From: Mark Peacock
Sent: 24 November 2016 11:40
To: Planning
Subject: FW: Northaw, The Oshwal Centre, Coopers Lane Road, 16/1600/LB

From: Andrew Robley
Sent: 04 November 2016 19:11
To: Mark Peacock
Subject: Northaw, The Oshwal Centre, Coopers Lane Road, 16/1600/LB

The site is the former large Country House known as Hook House, Regency Period, begun in 1839 of white painted stucco and generally with low-pitched slate roofs. However, the North elevation was partly extended in the late C20th with a single storey flat roofed part and a two storey pitched roof element. It is clear, from the architectural quality of the windows and other features, that the house was designed to be seen from all sides, in an open parkland setting.

DRAWING TITLE WINDOWS 21-22-23	
DATE 15.05.2015	DRAWN BY DP
SCALE VARIOUS@A1, VARIOUS-1/2@A3	CHECKED BY LV
DRAWING NO. 6842-61-P0	REVISION

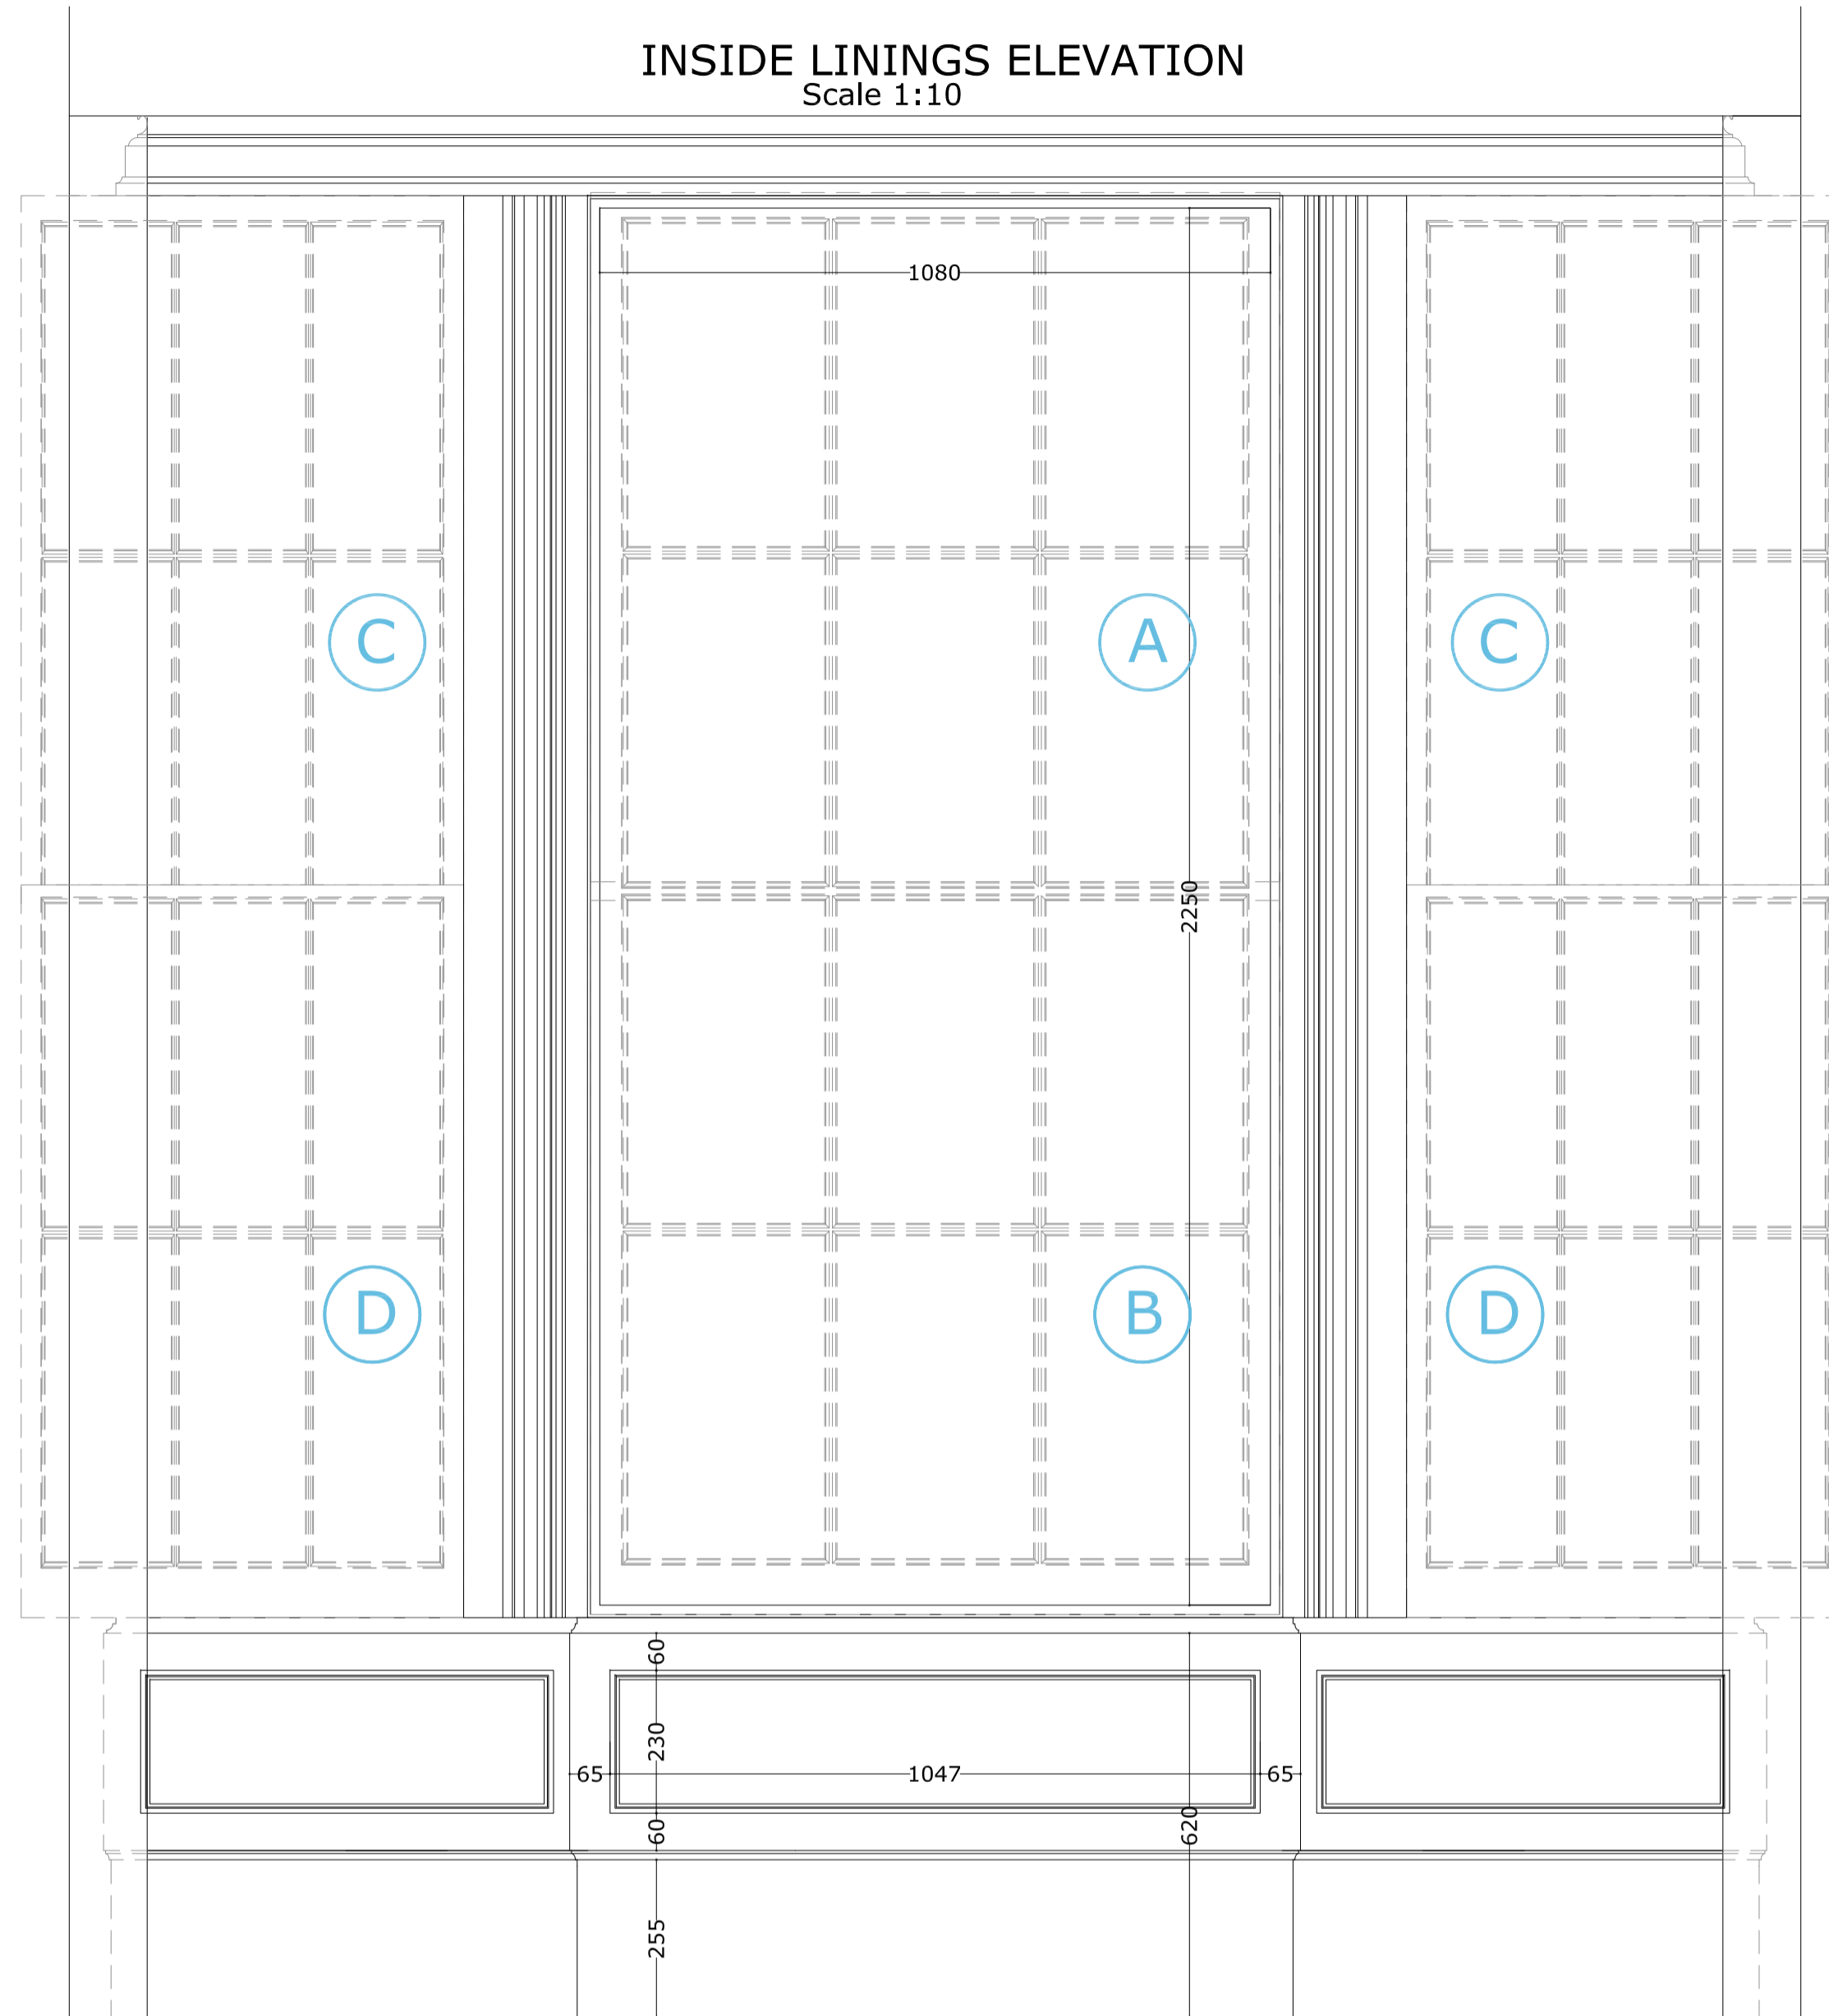
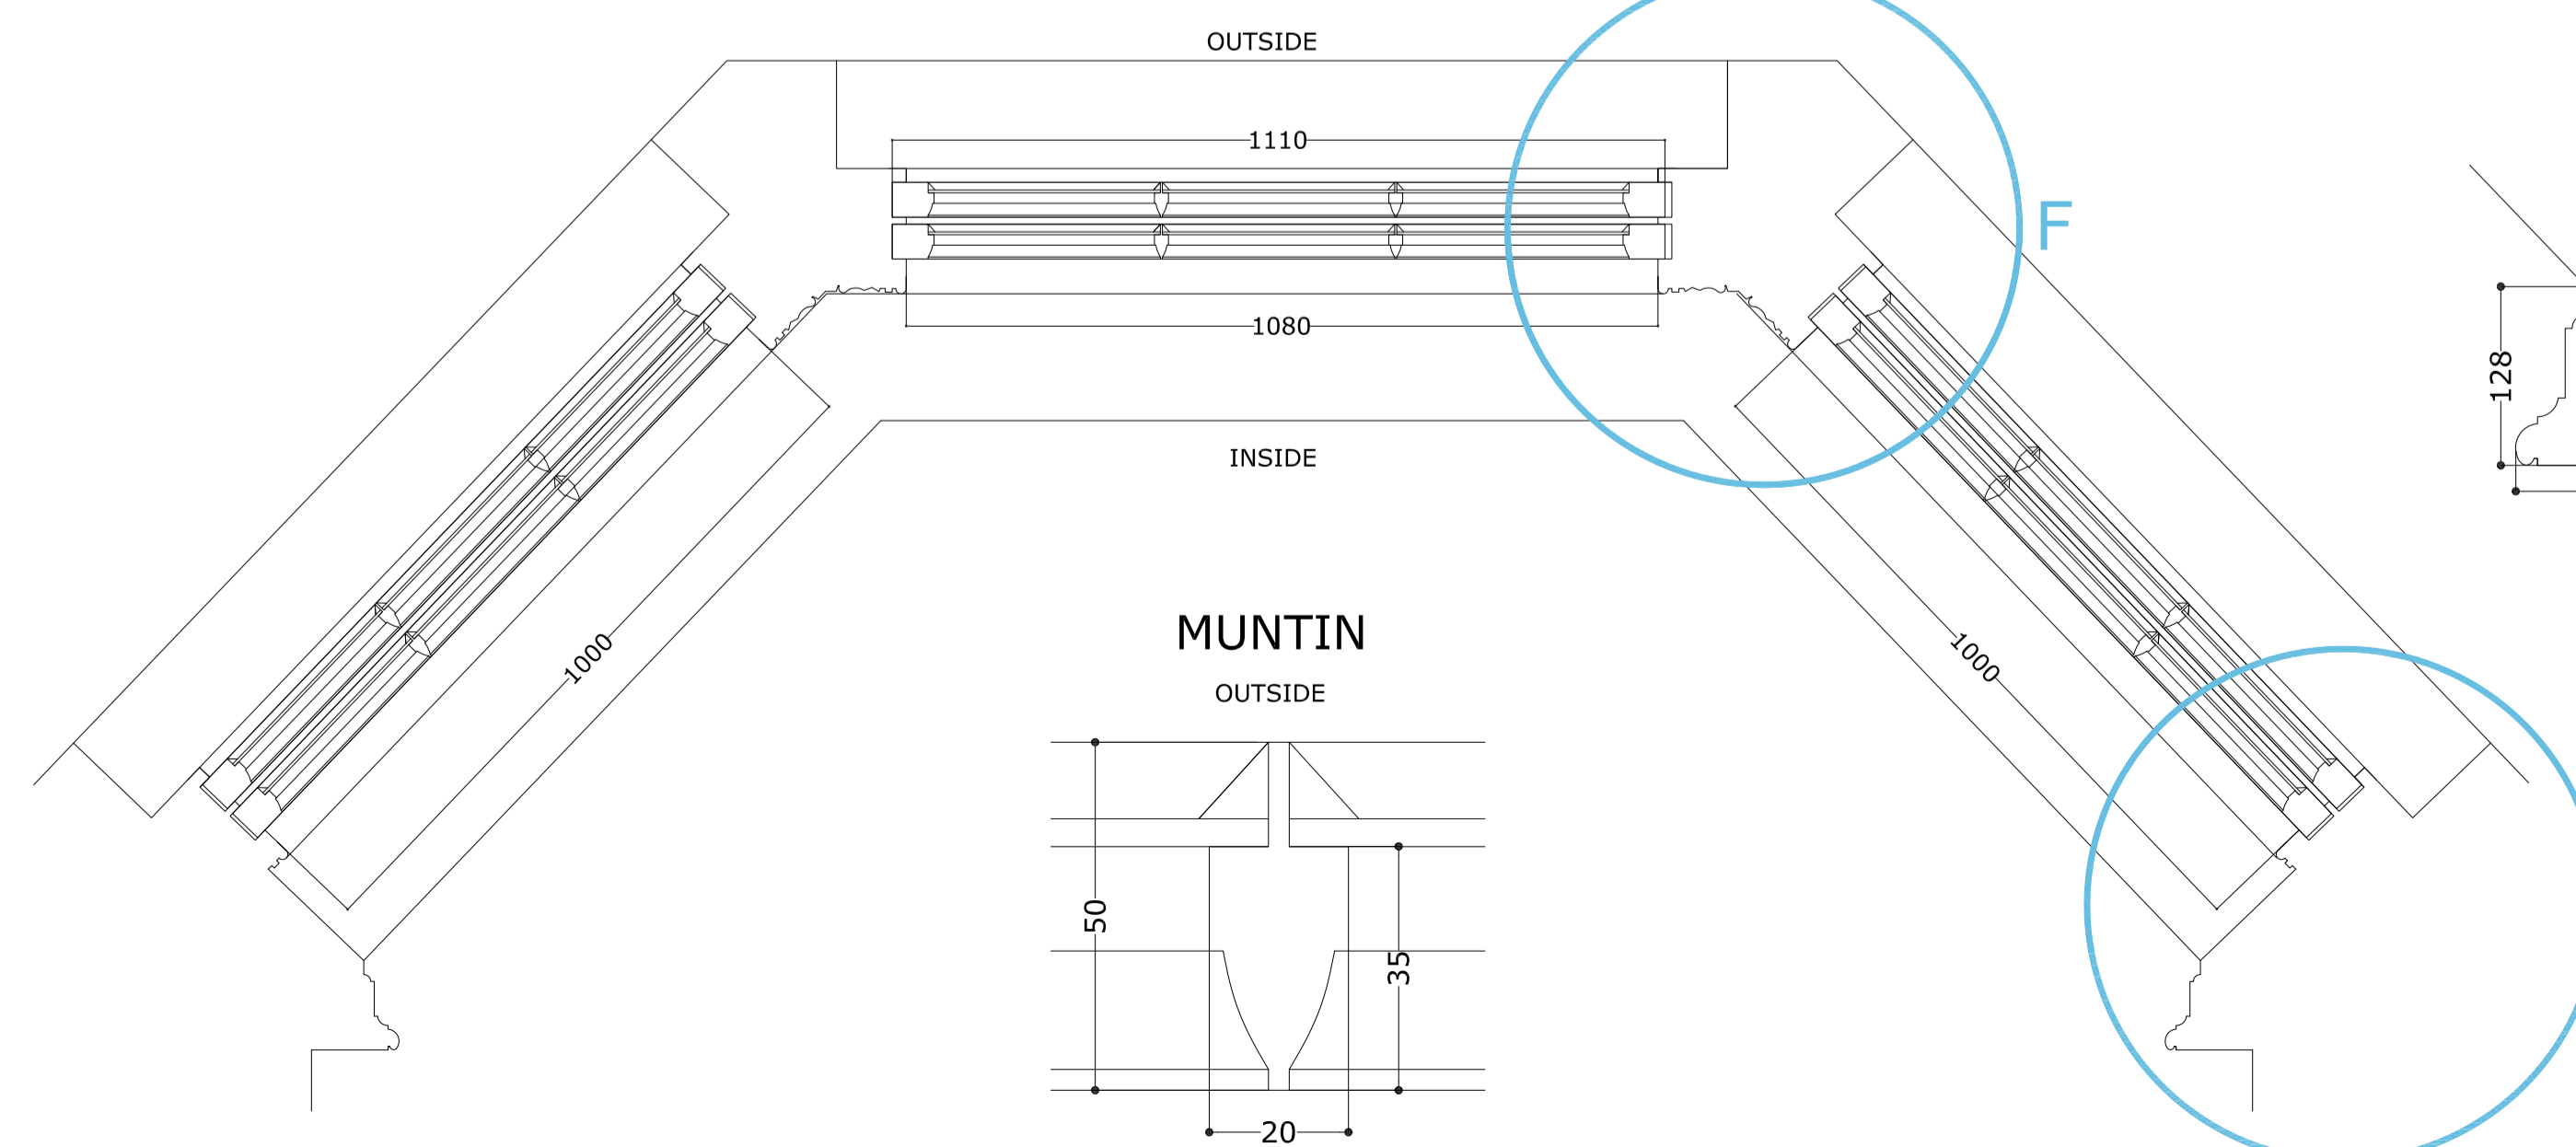
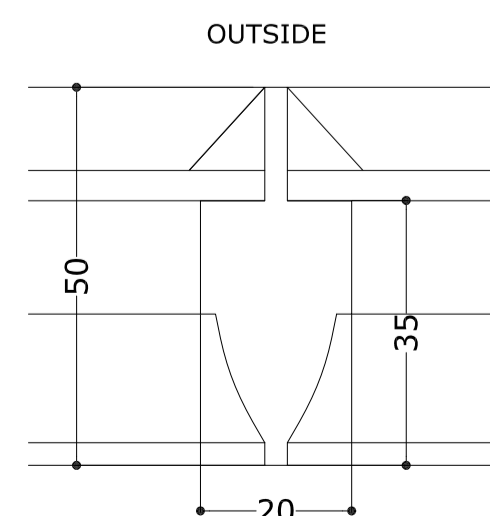
Following my site visit however, I can confirm that nearly all the windows are original and historic and contain some original or early cylinder or crown glass. There is some decay in the some of the windows largely in the usual locations of bottom rails and sills. They have not been painted externally for some time and the Heritage Statement refers to this. Many of them still have their original shutters. On my visit it seemed that most rooms were unoccupied.

Windows: In a Regency House, the slim recessed "Georgian" sash windows are a particularly important architectural element. It is the period when glazing bars were at their finest and this is certainly the case here and the glazing bars are particularly fine. To replace these windows would irreversibly denude the building of much of its authenticity. The windows have been left unpainted for too long but all of the original ones are repairable. The Architect has ascertained that the decay is mostly due to dampness getting in through cracks in the render and/or lack of external paint protection and what he calls "humidity".

The proposed window replacements are not even like for like in detail or in material and would not be acceptable in any case. The "glazing bars" are merely stick on applications to mimic the real thing.

The works should be reconsidered: A survey by a conservation accredited Architect or Surveyor should be a pre-requisite for works of this extent. The aim should be to retain all of the historic windows, repair and upgrade them if necessary in accordance with Historic England advice , using alternative, more conservative strategies for achieving better performance and greater longevity of paint systems. Original render (if any should be conserved) and any replacement render should be compatible with any surviving original stucco or else good historic rendering practice and cent should not be used either in the r ender or any repointing . The causes of dampness and decay need to be properly established prior to specifying any work.

DRAWING TITLE  
 EXISTING ELEVATIONS

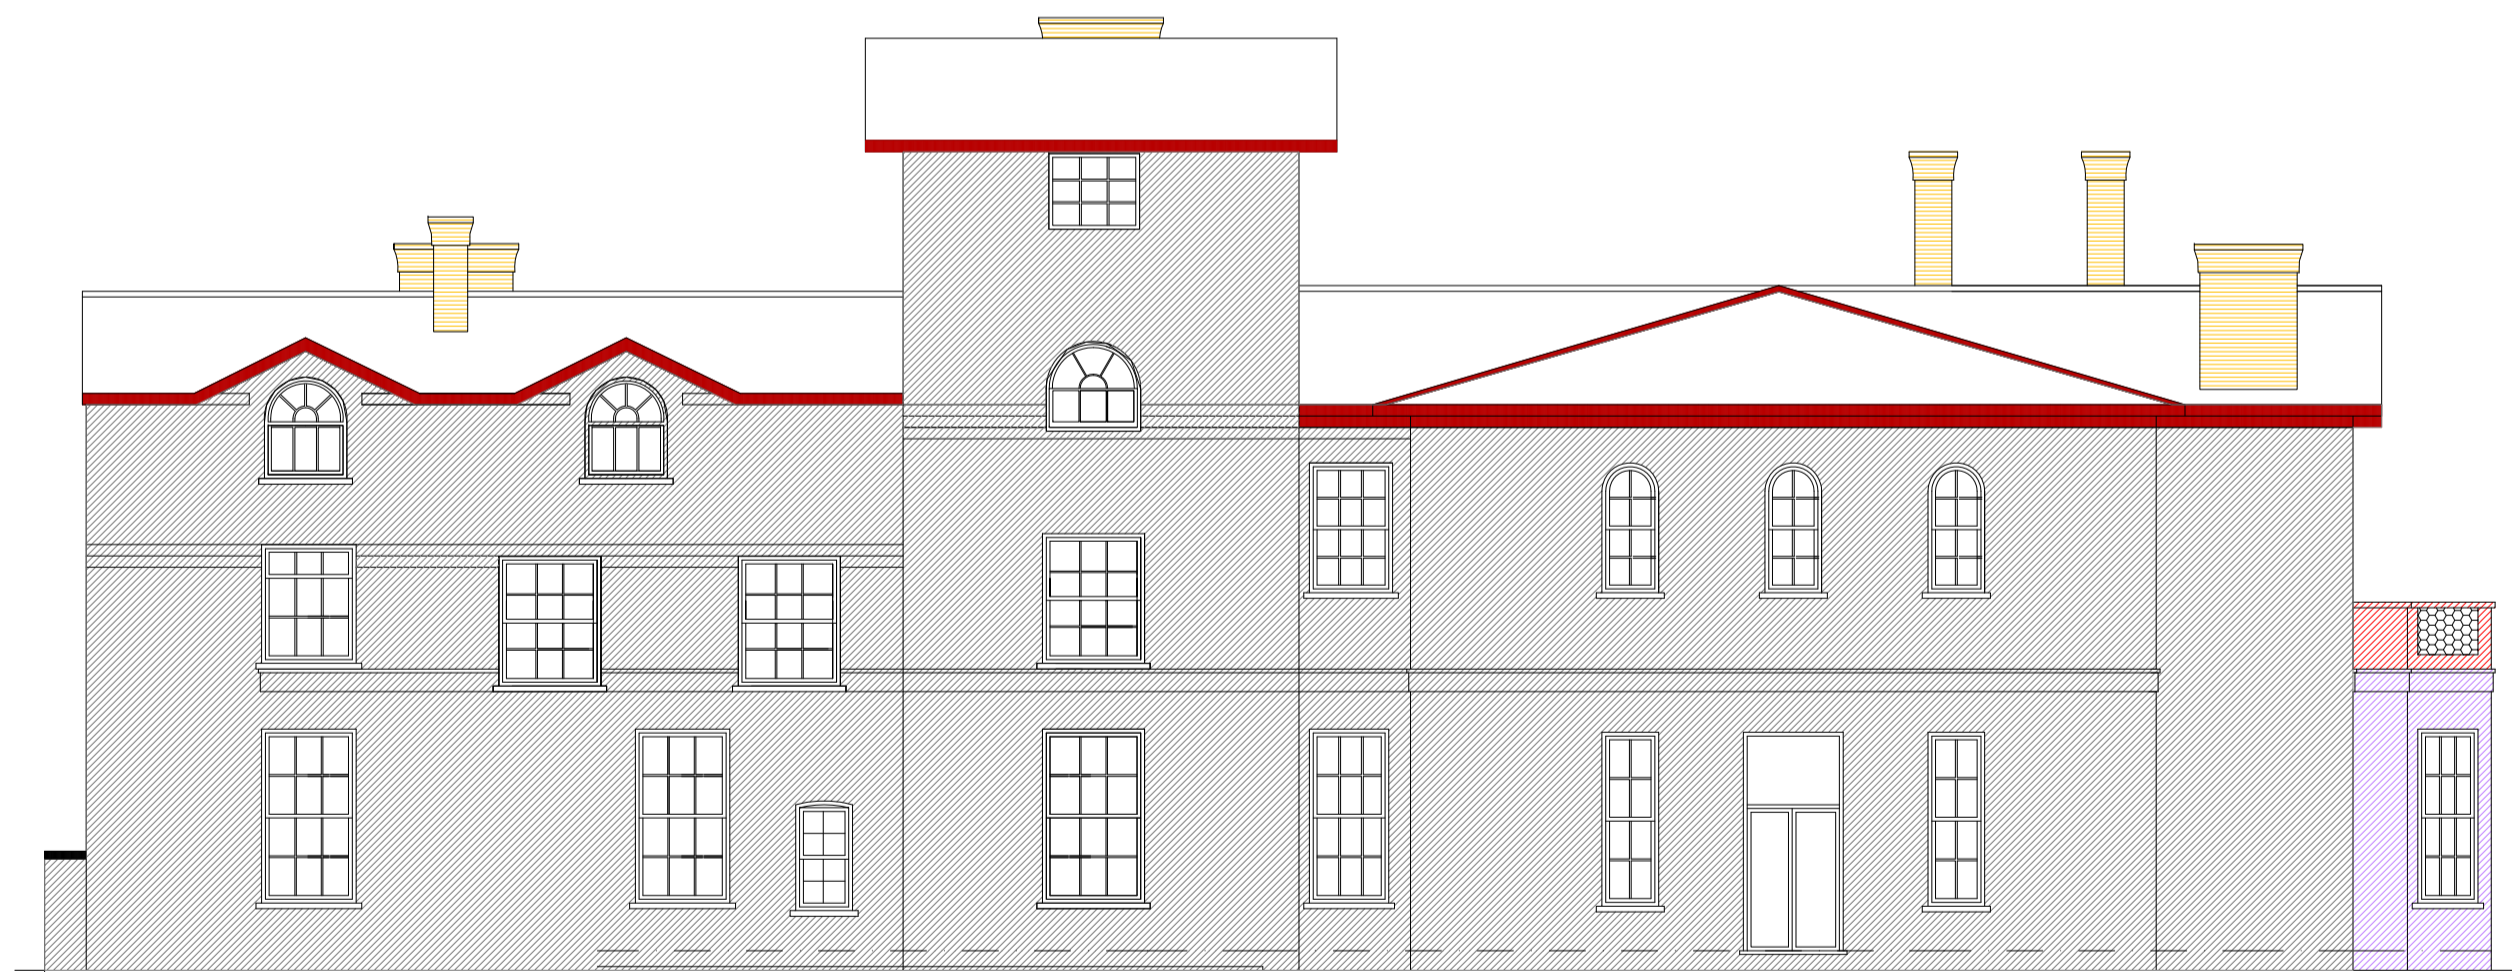
Some of the rendering is probably modern but it is not certain without proper investigation whether any remains original or whether there is original rendering under a modern cement based skin. The information supplied is deficient in that there is insufficient advice in this regard. What is evident from my site visit is that some of it is cracked and some distorted especially I near ground level and around sills.

Rendering: Painted stucco is also an essential component of many Regency Houses. It is important to retain original stucco where possible but it is not certain whether all or any of the current render is original stucco. The Heritage Statement offers no back up information as to the originality or not of the existing stucco but nevertheless, the proposal is to remove the whole lot. This would not be acceptable without evidence that it is all modern render and therefore not worthy of retention. However, it is clear that some of the render is defective and would at least need to be repaired. Nevertheless prior to this, there should be some analysis of the original render so that the repair can be compatible. Even it is established that it is modern cement, if this is then to be removed it would be a missed opportunity to replace it with cement render as specified in the schedule of works, because it tends to crack easily, and to trap moisture in the fabric, leading to further failure, damp penetration and decay of timber. The proposed use of metal plaster stops and angles would be too sharp and not in keeping with the originally crafted corners.
